PLANNING AMENDMENT

High Street, Gosberton

Proposed residential development:
application for Approval of Reserved
Matters

Residential Development, High Street, Gosberton for Eastman Securities Ltd

PROPOSED SITE LAYOUT		DATE	DR.	CHD.
1:500	SCALE	OCT 1995	RAW	
2081E-94-30A		DRAWING NO.

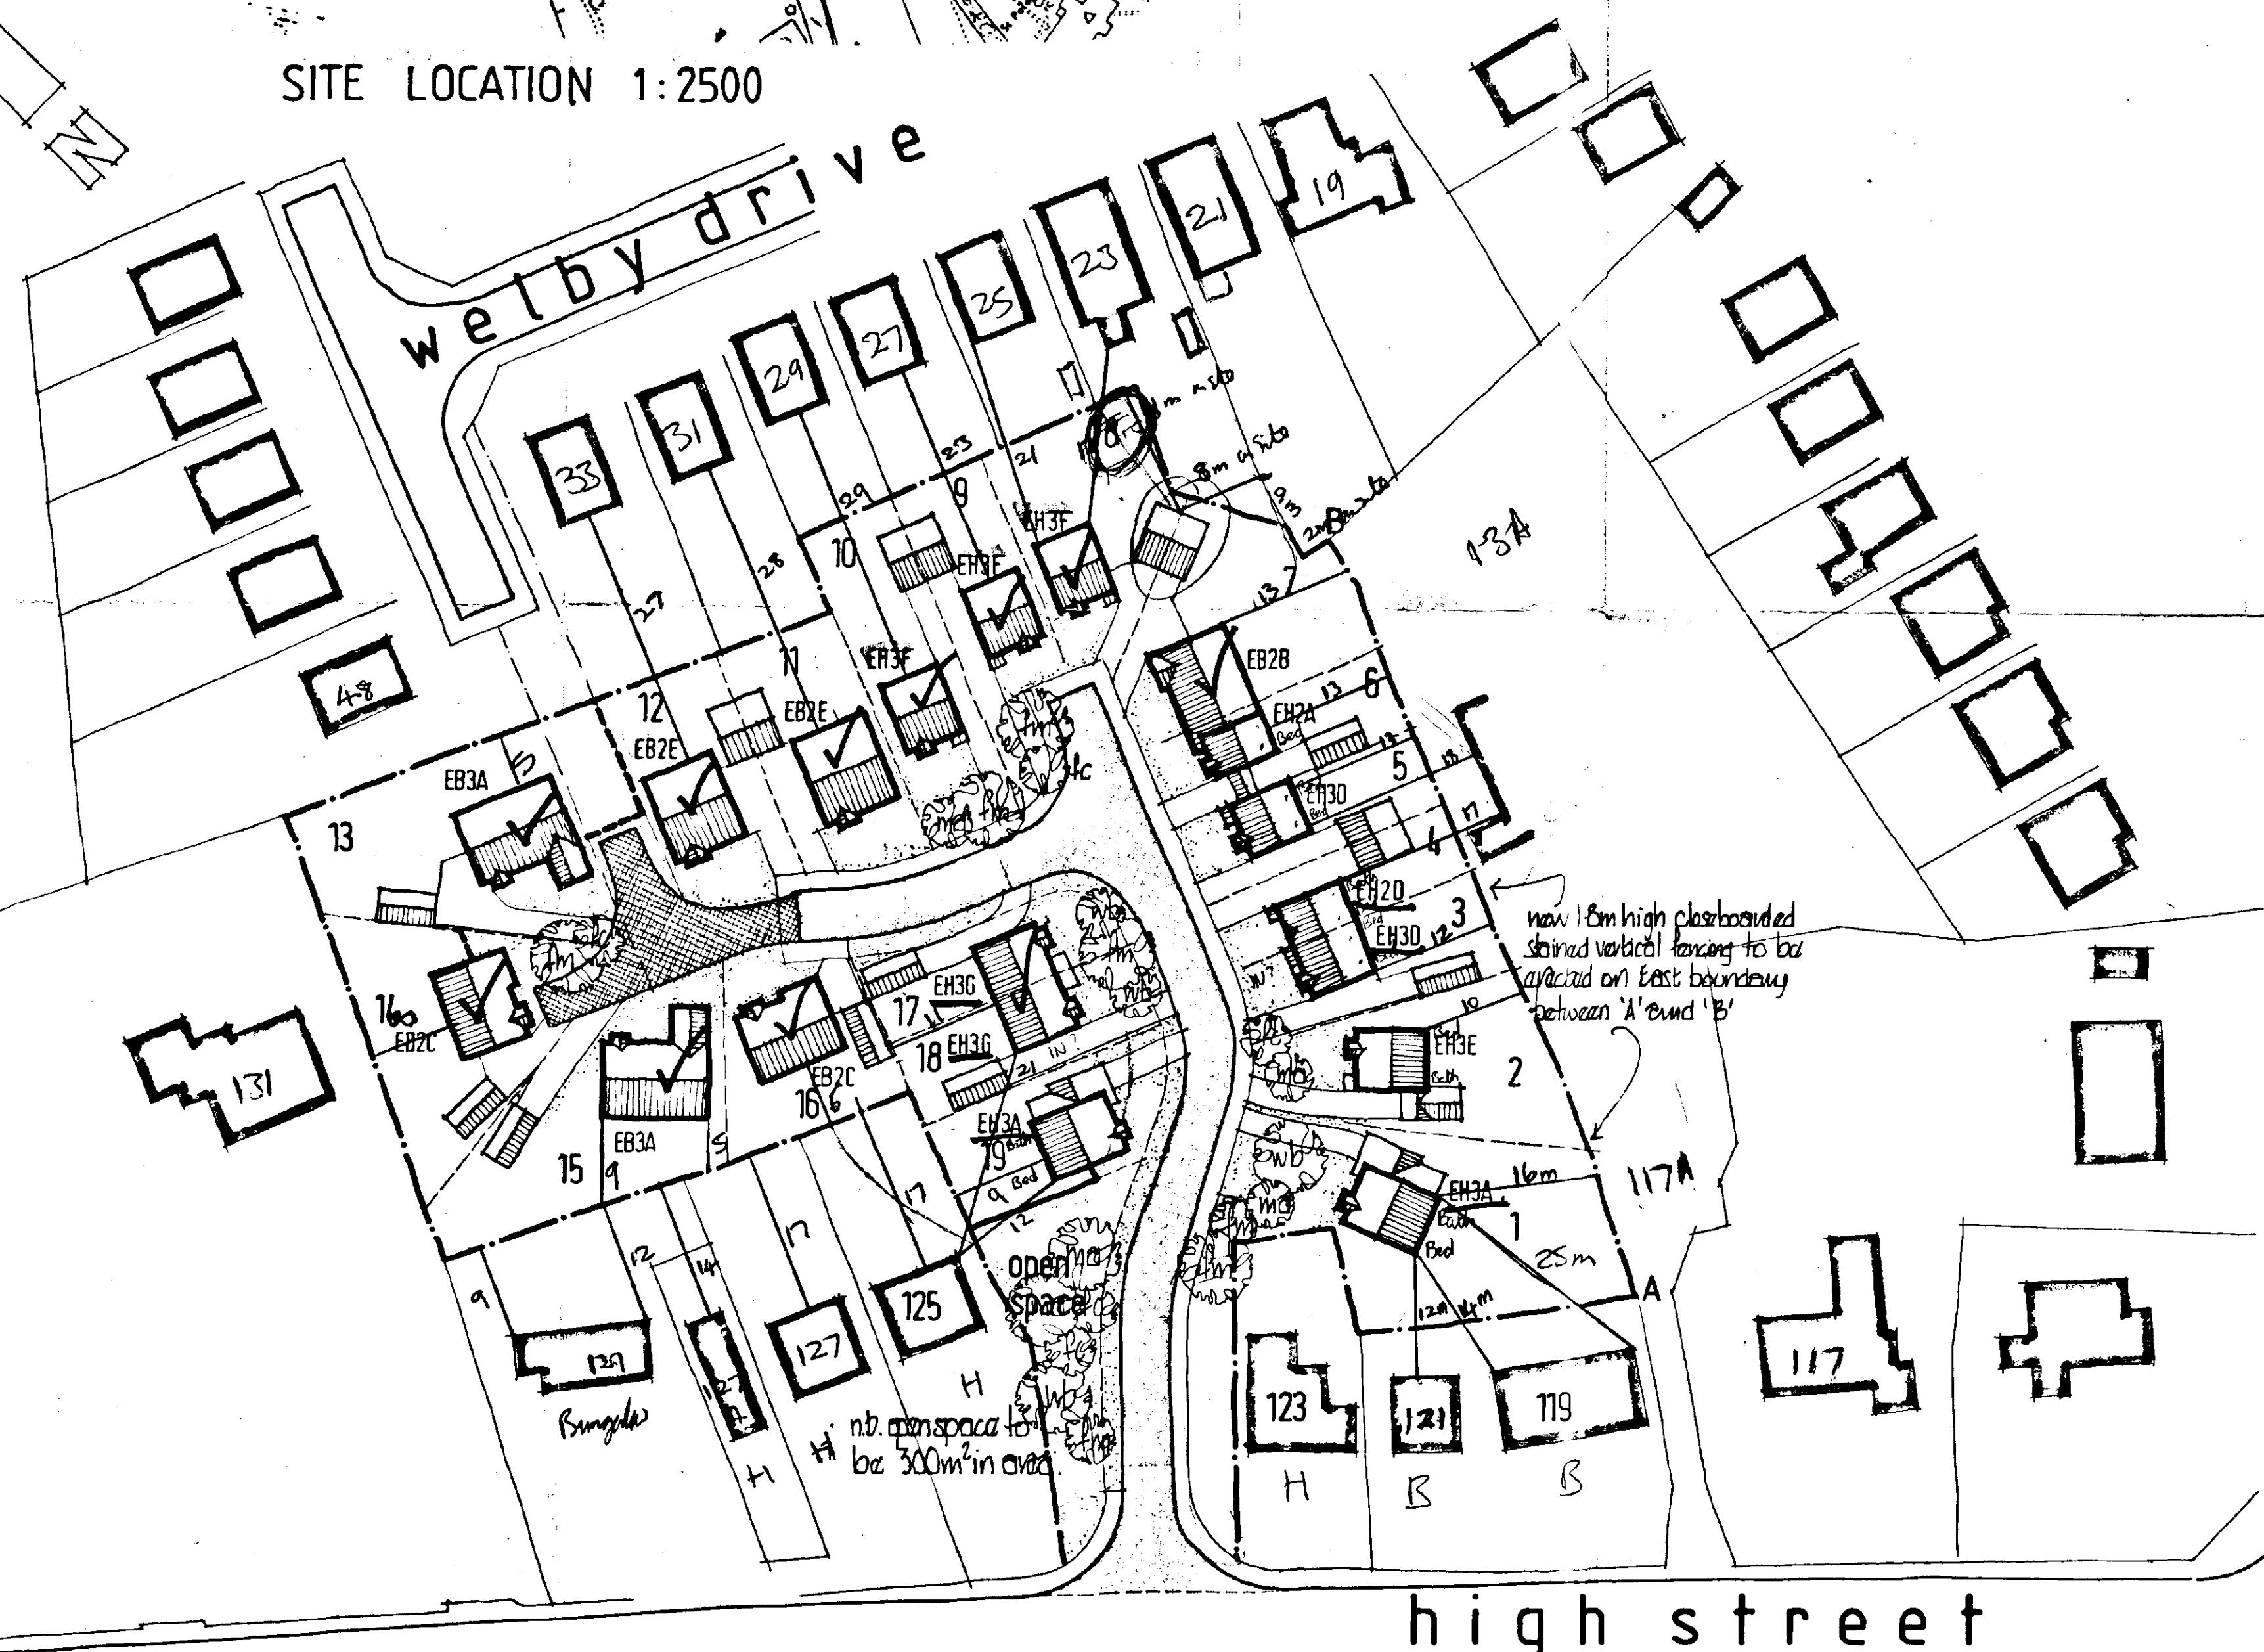
Further to your letter dated 6 December 1995 regarding the above planning application, please find enclosed four copies of the Planning Amendment form, four copies each of our amended drawings nos 2081E/14F and/30B. The amendments as being requested in your letter dated 6 December 1995, garages to Plots 7 and 8 have been resited.

Existing garages on plots
 3, 4, 5 & 6 - garages moved
 approx 500 - 700 mm eastwards

It would appear that the submitted amended drawing ref: 2081E/94/5 N is similar in dimensional terms to the drawing ref: 2081E.94.30B. The differences appear to be the positions of the garages on plots 3, 4, 5 and 6. Although the difference may be minor in the context of the whole development it is considered to be a significant alteration in relation to the relationship with the neighbouring property. Given the fact that the garages are closer to the boundary with the main objector to the development of this site and who has officially complained to this Council about the processing of the application with a view to complaining to the Local Government Ombudsman it is not considered that the alterations can be authorised under the amendment procedure.

I have received details of the above development which you wish to have accepted in lieu of those previously submitted. However, I consider that the changes are too significant to be treated merely as an amendment and that therefore a fresh application for planning permission should be submitted (forms enclosed).

CAD
WORKING DRAWING TYPE EH3A
1:50 1:100 SCALE JAN. 95. DATE
2081E/94/14 F
DRAWING

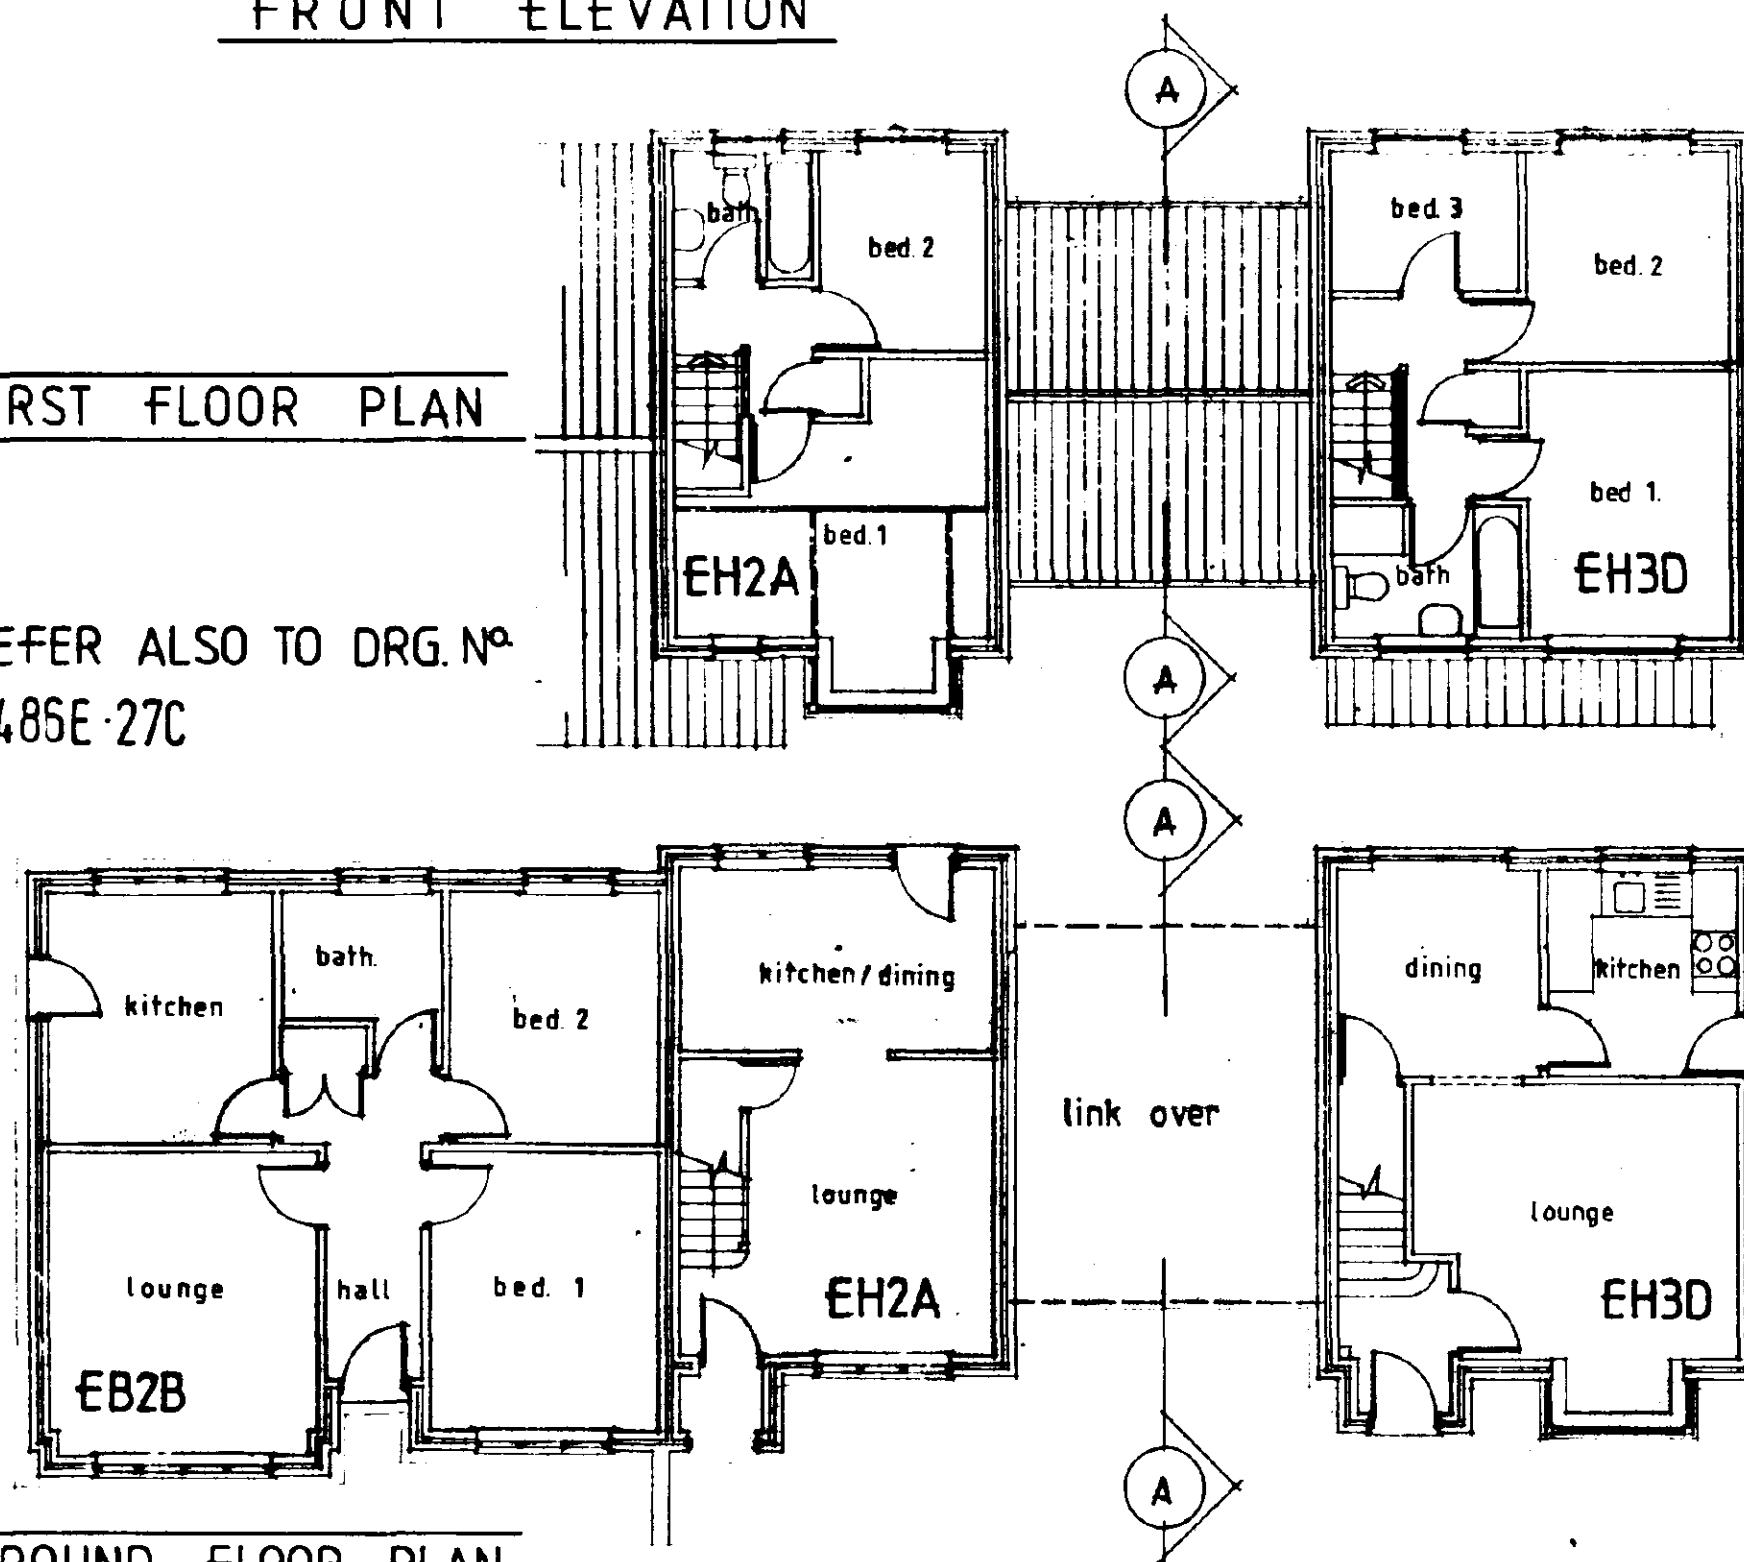
Plots 1 & 2 handed, further tree planting
added, bed 2 window to Plot 19 moved

The amended details submitted in respect of the above proposal have now been considered, and I am able to inform you that there are no objections to the amendment being implemented to the extent described above.
